SUBMISSION BY THE MERIDIAN ACTION GROUP

MAG COMMENT ON Meridian's Connection to the National Grid National Grid vs Meridian

Title  
**MERIDIAN SOLAR FARM  
WORKS PLAN  
REGULATION 5(2)(j)  
SECTION B SHEET 4 OF 5**

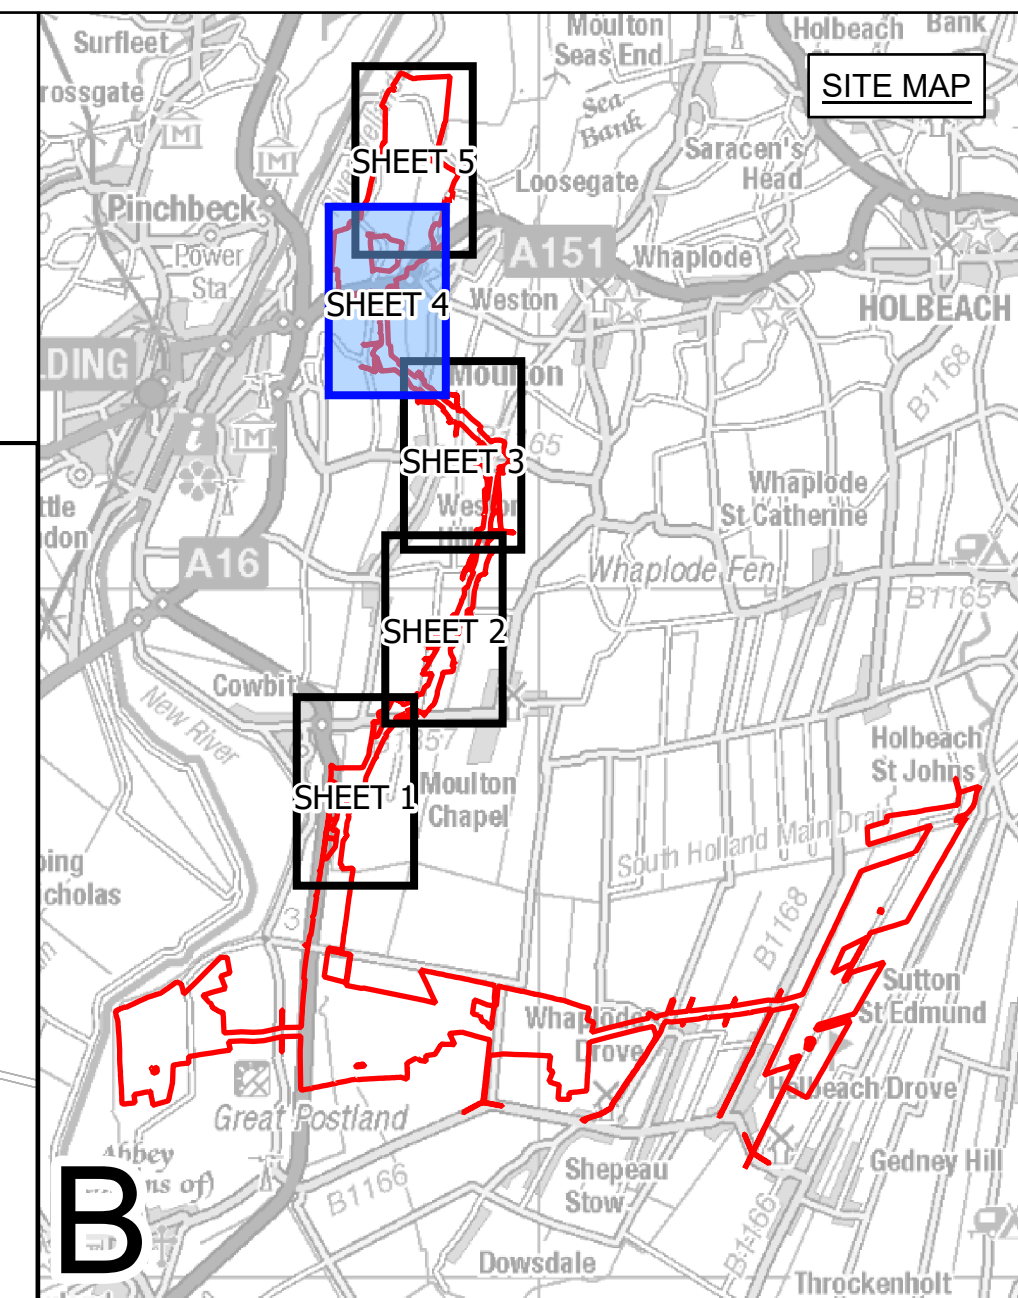
There are technical issues with the pylon line as it approaches Weston Marsh. As proposed there is insufficient clearance between the Meridian line and the proposed G to W line which would lead to operation and safety issues. NGET are not satisfied that both projects can be accommodated in this area.

The proposed G to W project is designated to be of wider importance, the presence of a further pylon line (up to 66m high) parallel to it on the approach to Weston Marsh would add considerably and unacceptably to the cumulative visual impact on the open and flat fenland landscape.
